# Planning Application 2016/1342/INVALID

**APPLICATION NO:** 2016/1342/INVALID  
**DESCRIPTION:** Demolition of existing subsidence damaged farmhouse and erection of a 4 bedroomed dwelling  
**LOCATION:** Poplar House Farm, 24 Low Cudworth Green, Cudworth, Barnsley, S72 8EF

BLOCK PLAN. 1:1250

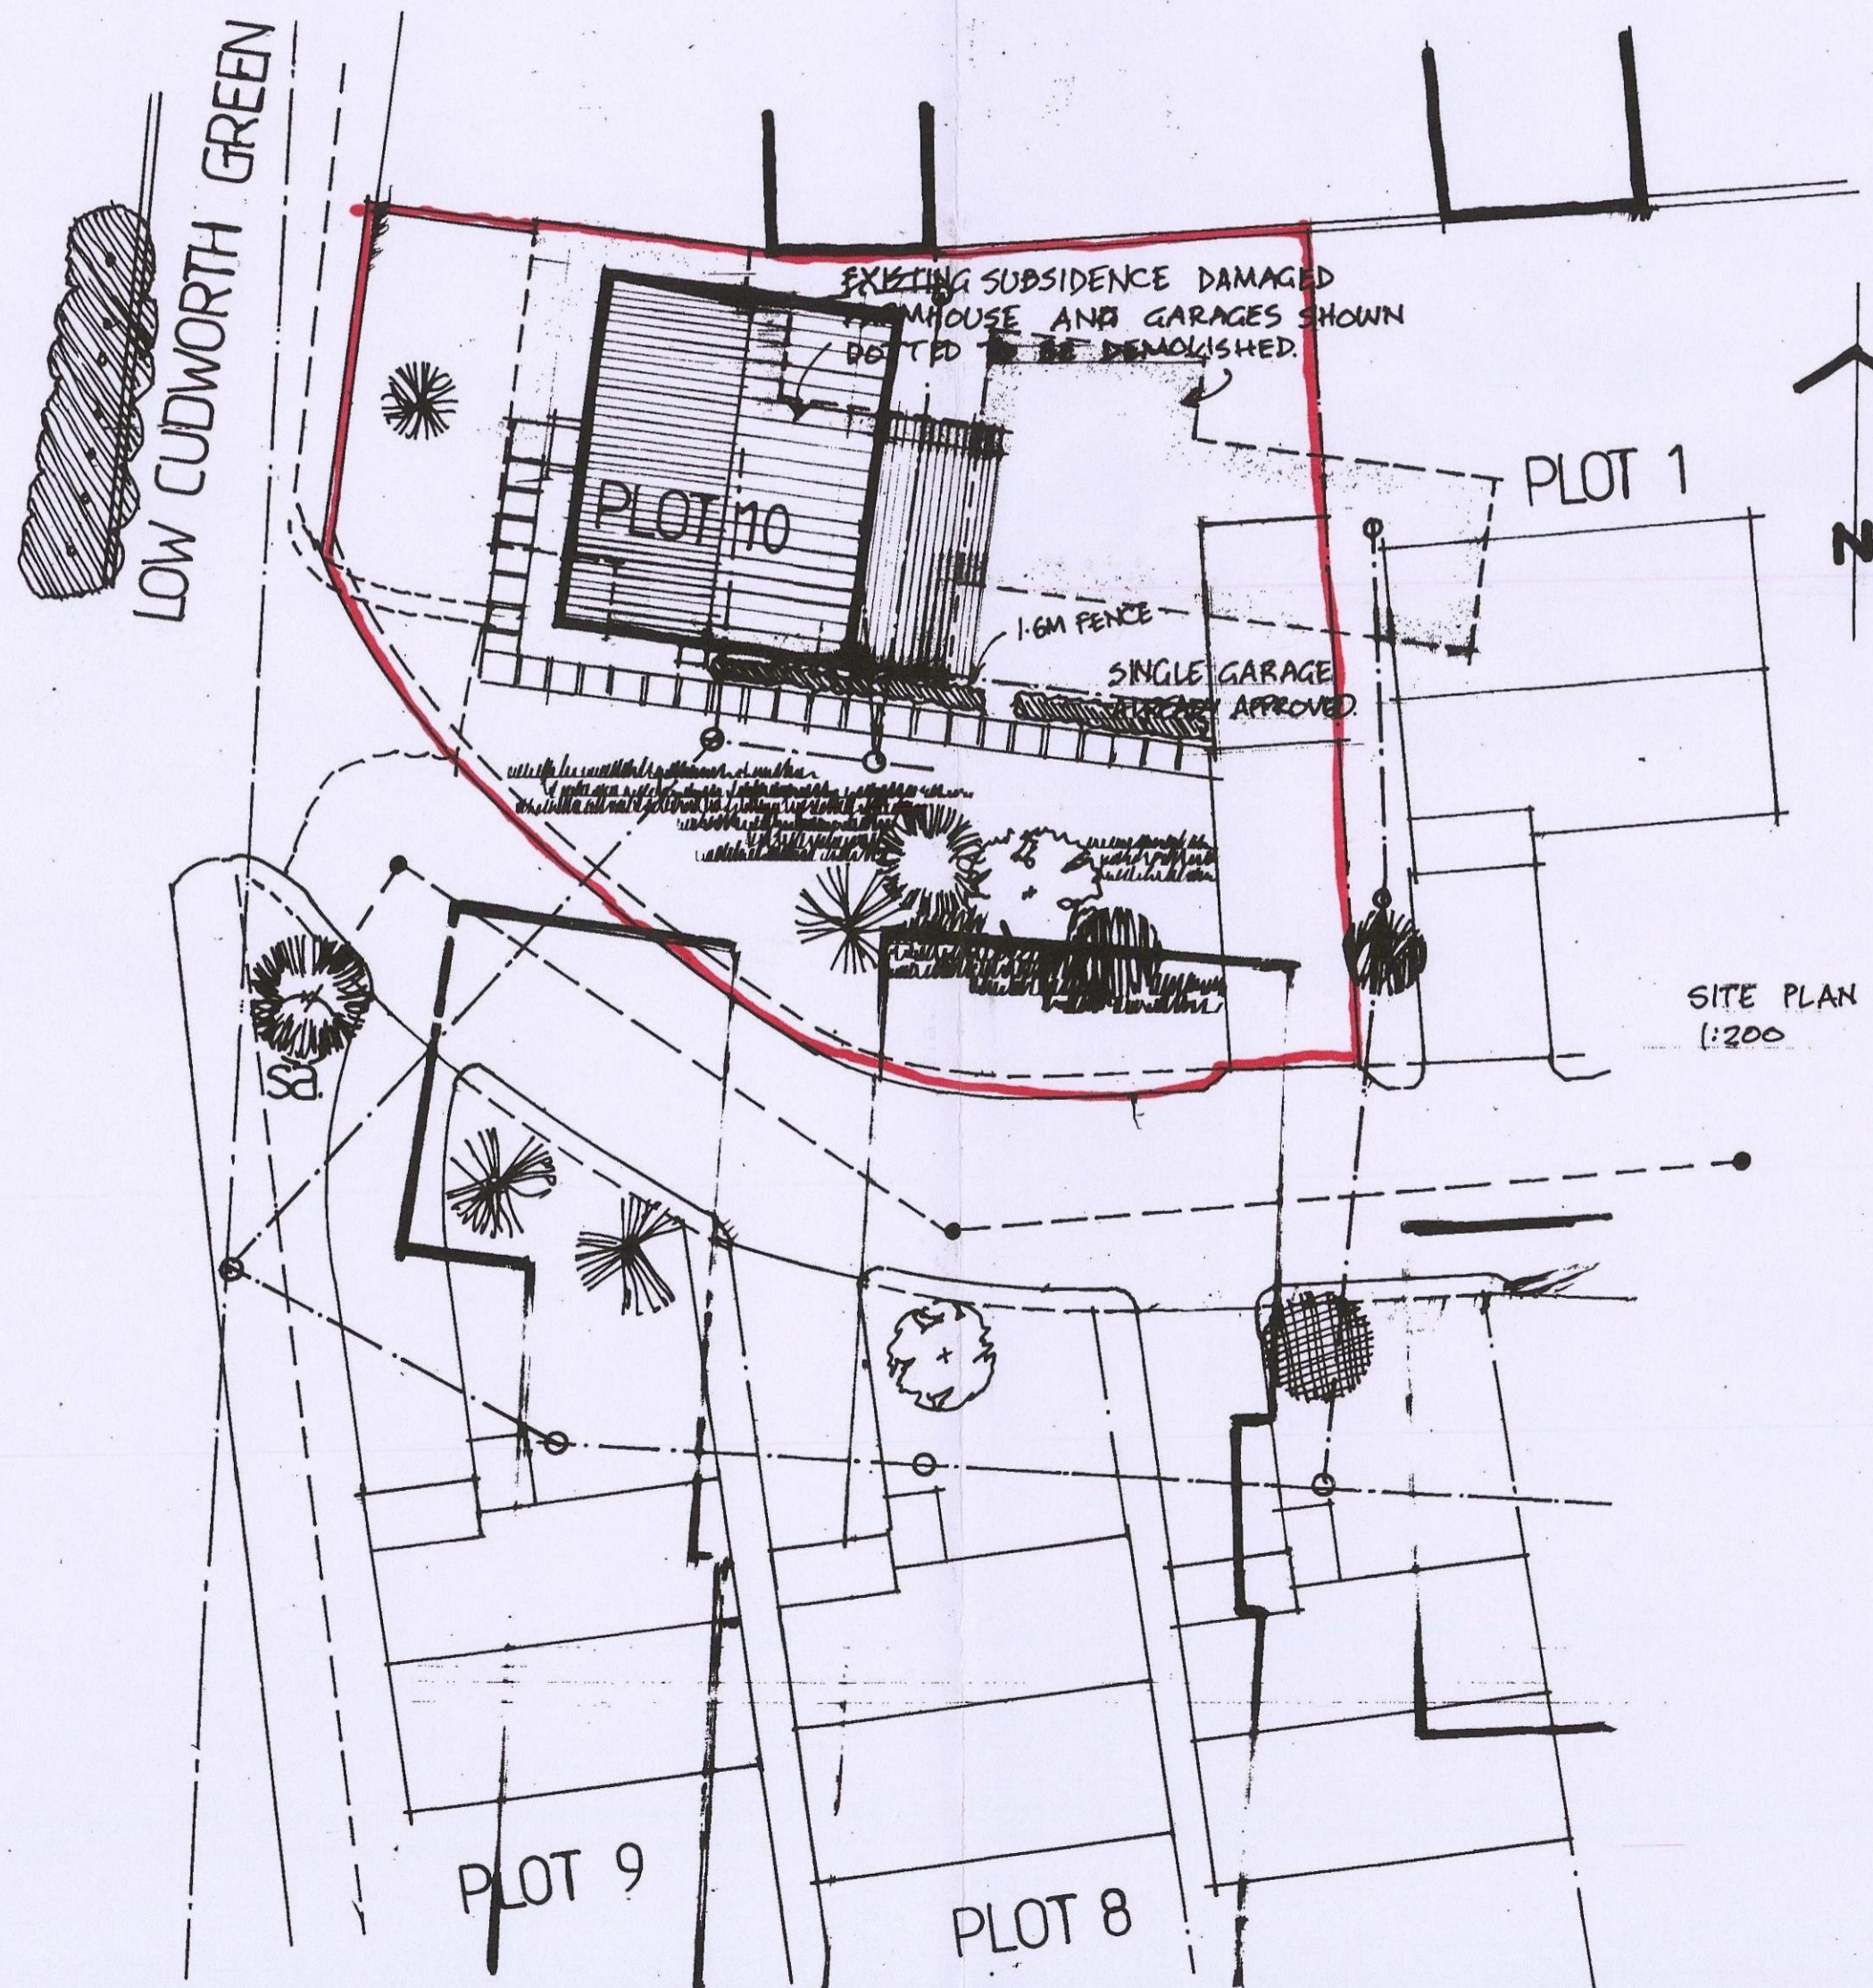
✓ **The red edge of the location plan should include the access up to the adopted highway.**
